**MAJOR PROJECT ASSESSMENT:
Coca-Cola Amatil Preform and Closure
Manufacturing Facility**

Director-General's
Environmental Assessment Report
Section 75I of the
Environmental Planning and Assessment Act 1979

April 2011

26.0m B-DOUBLE VEHICLE SWEEP PATHS

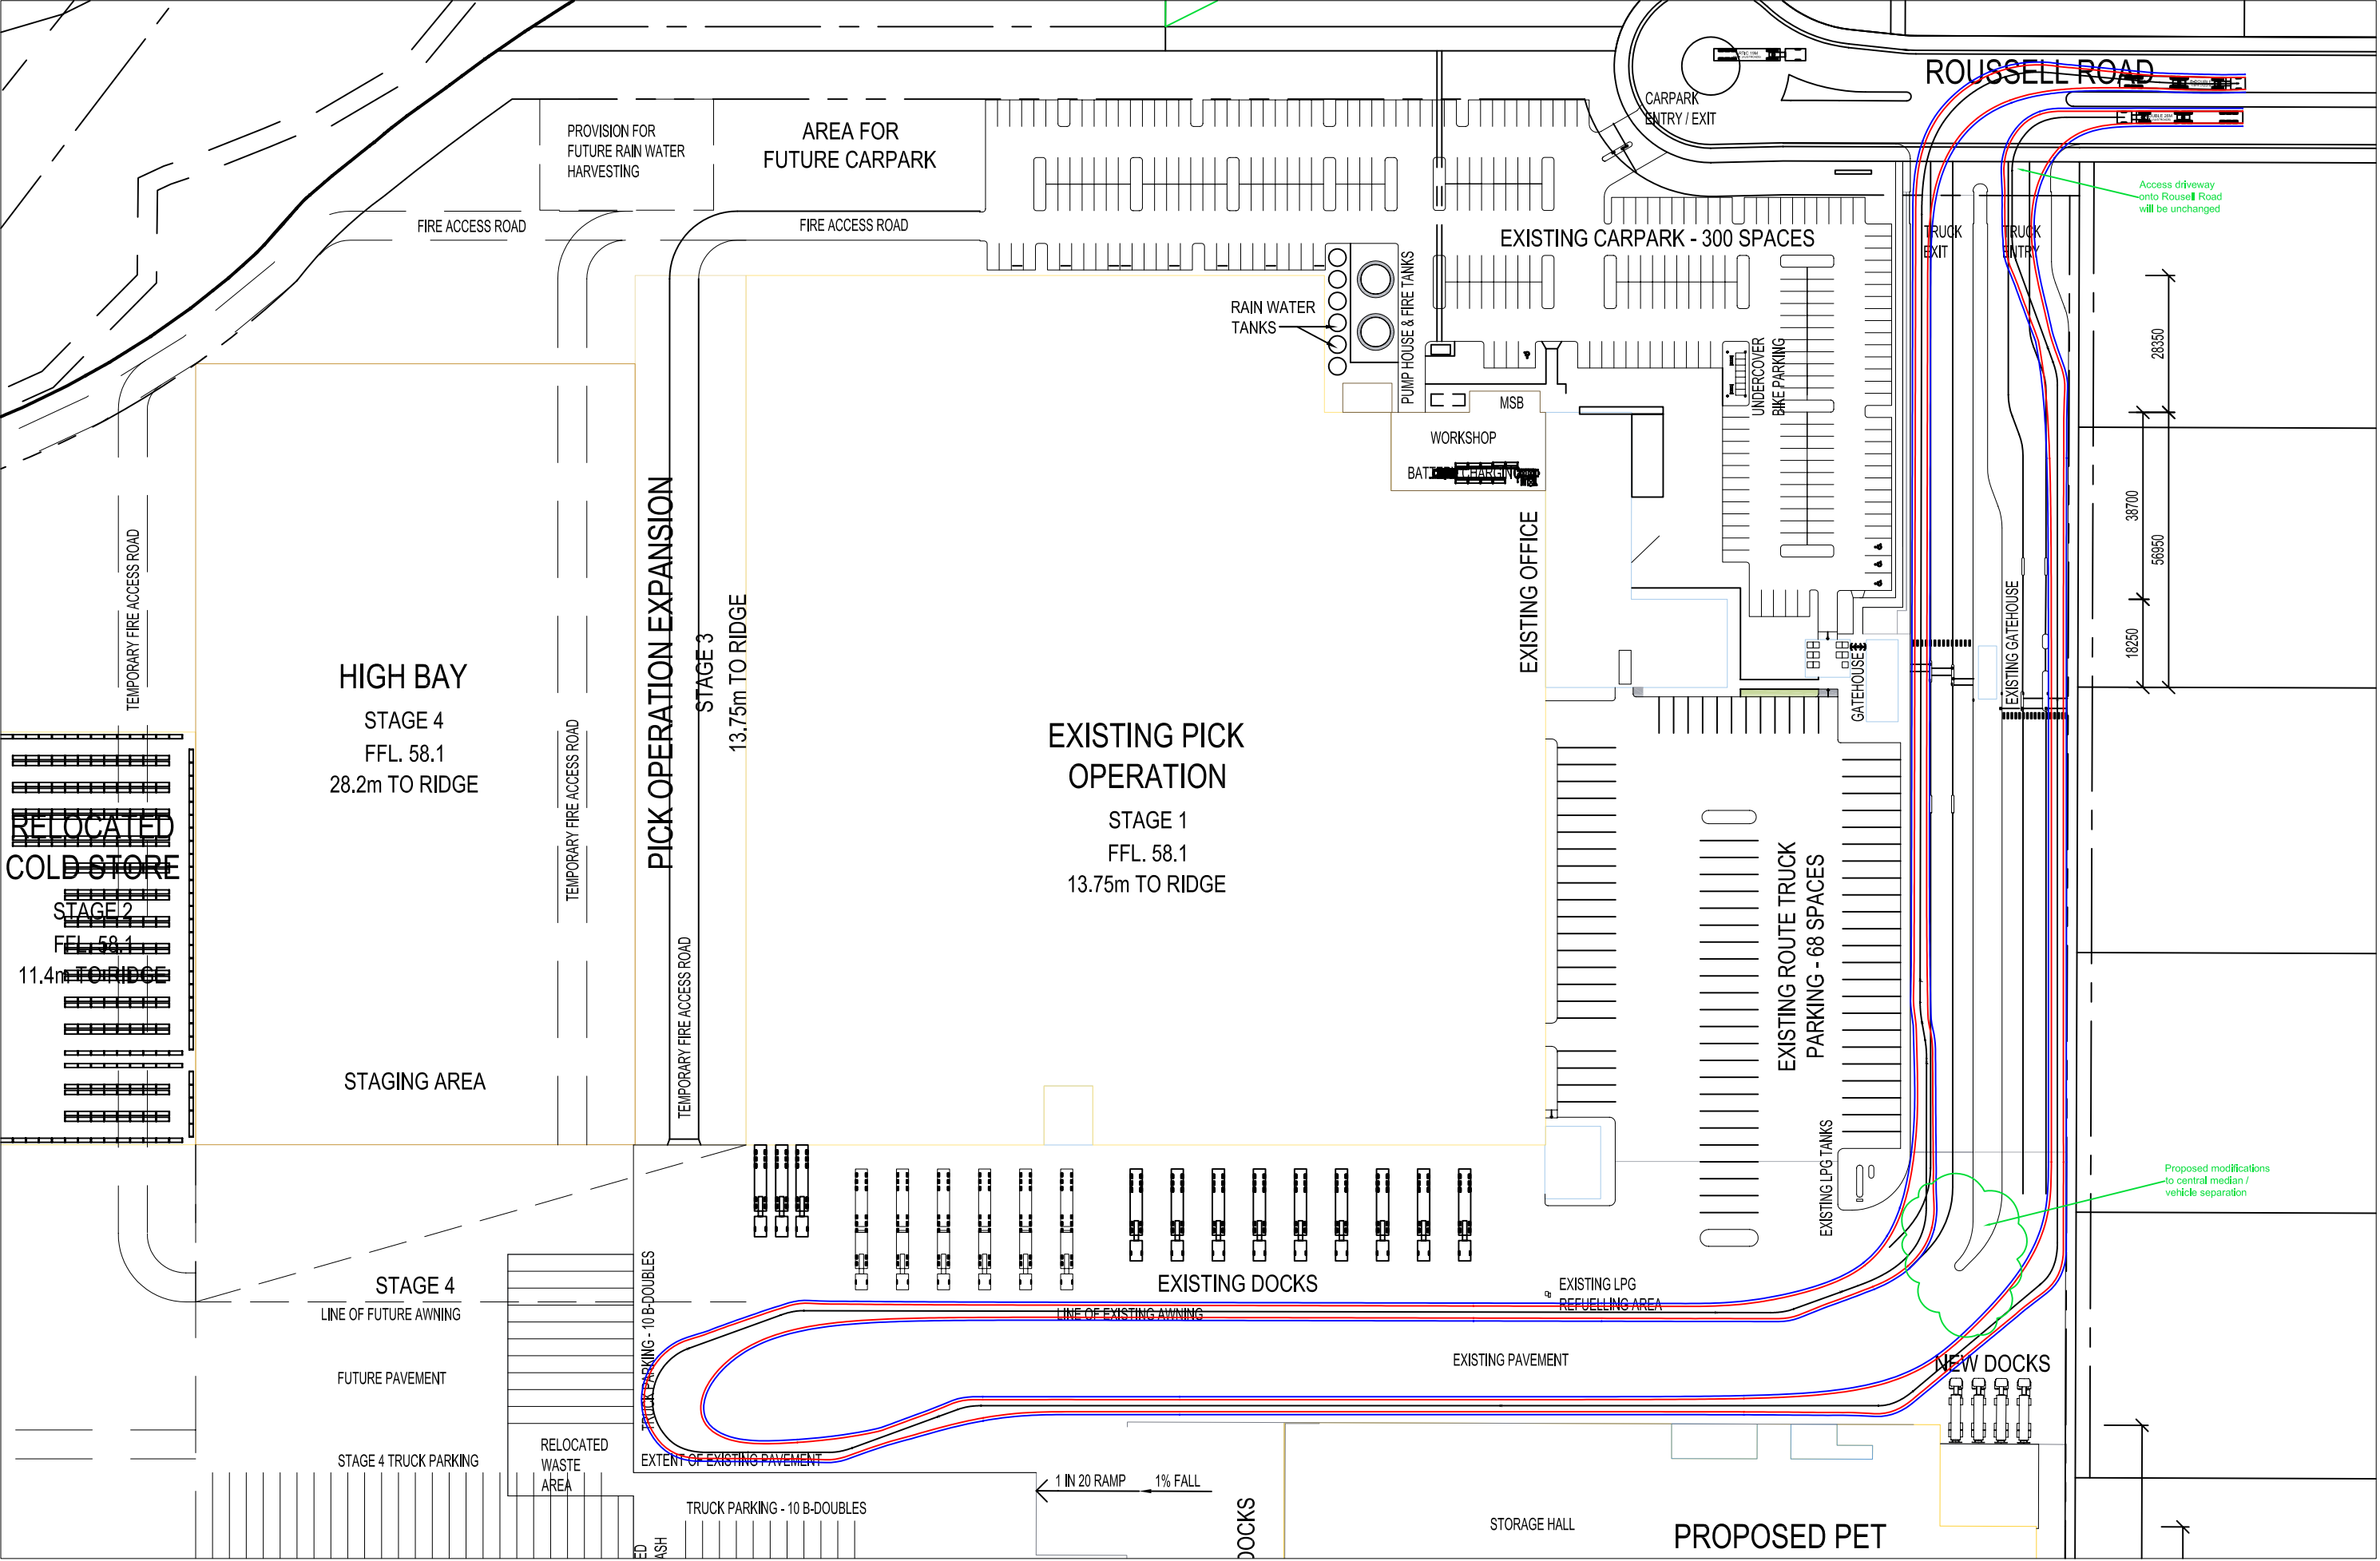
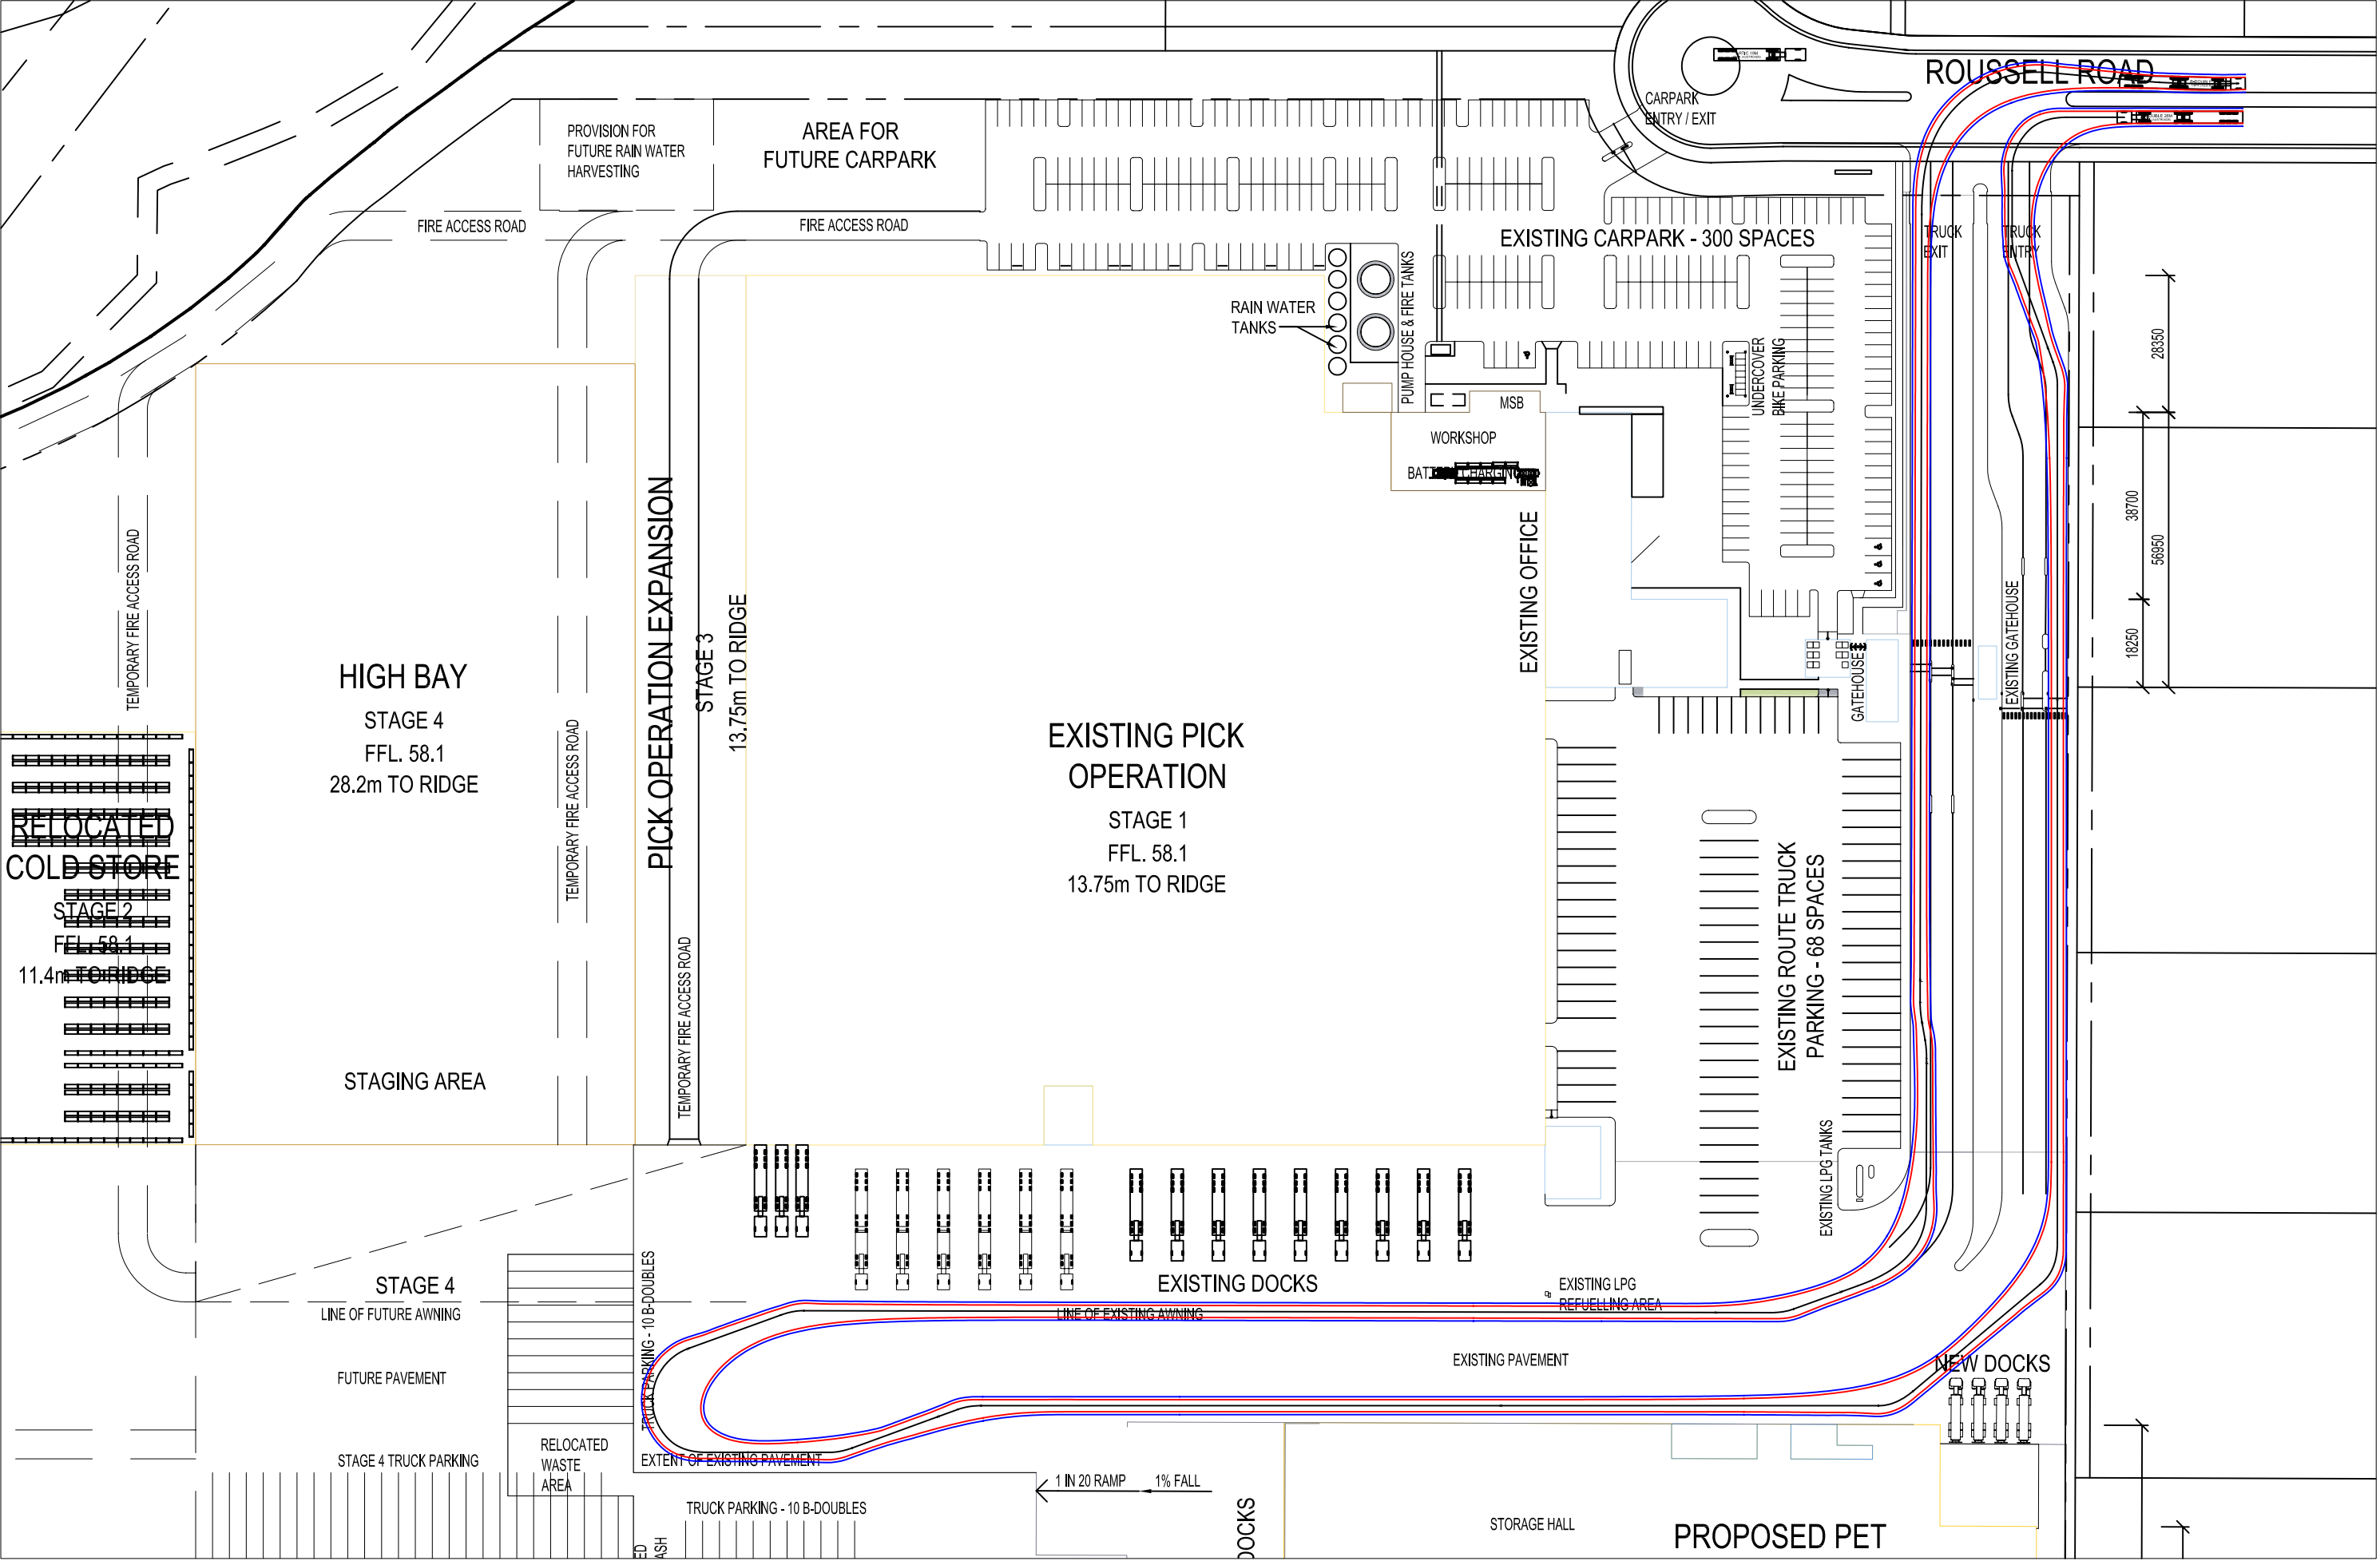
The Roads and Traffic Authority (RTA) raised concerns with regards to car parking, manoeuvrability of traffic including garbage trucks on site, the swept path and traffic movement directions. These issues have been resolved through recommended conditions of approval.

Colston Budd Hunt and Kafes Pty Ltd have assessed the circulation within the centre, and to and from the proposed development. The Department considers that the circulation pattern and truck movements are capable of accommodating all necessary movements for access and circulation through the site.
